Subject: RE: Planning Consultation on: P/38/21/PL

Application No: P/38/21/PL

Site Address: Little Seftor Farm Pagham Road Pagham

Description of Works: Extension to existing agricultural barn. This site may affect the setting of a listed building & is in CIL Zone 5 (Zero Rated) as other development.

**Figure 1: Development and Mitigation Proposals Plan**  
 Extension of Agricultural Barn Facility, Little Seftor, Pagham  
 Preliminary Ecological Assessment GPM Ecology, Feb 2021

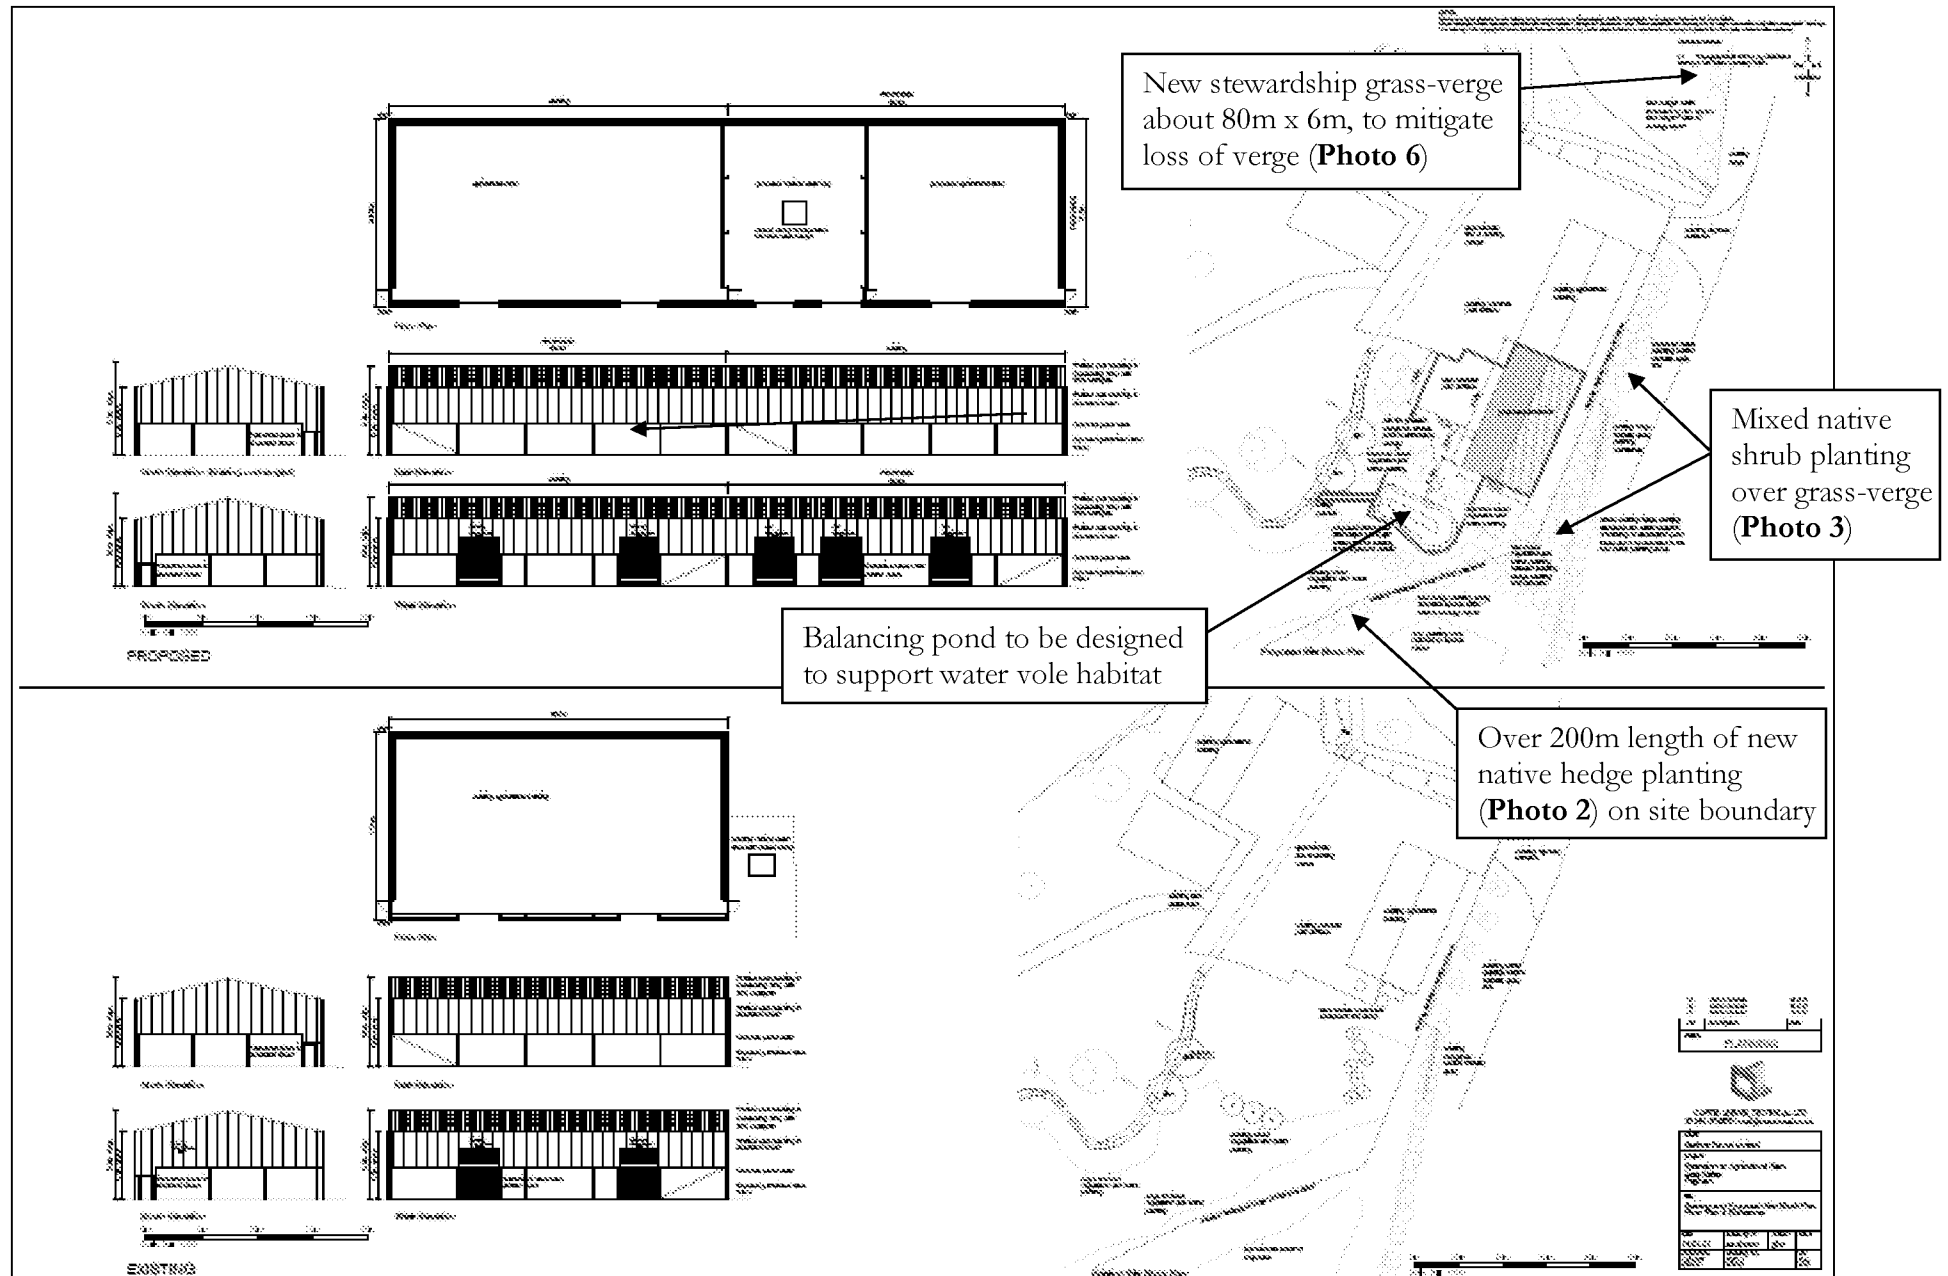
Should permission be granted, the mitigation within sections 4 and 5 of the ecology report should be conditioned, including the following:

A landscaping plan will be required detailing the following mitigation/enhancement features:

- New woodland creation;
- New hedge planting;
- Arable grass-verge creation;
- Balancing pond and ditch outfall;

A Landscape and Ecology Maintenance Plan will also be required.
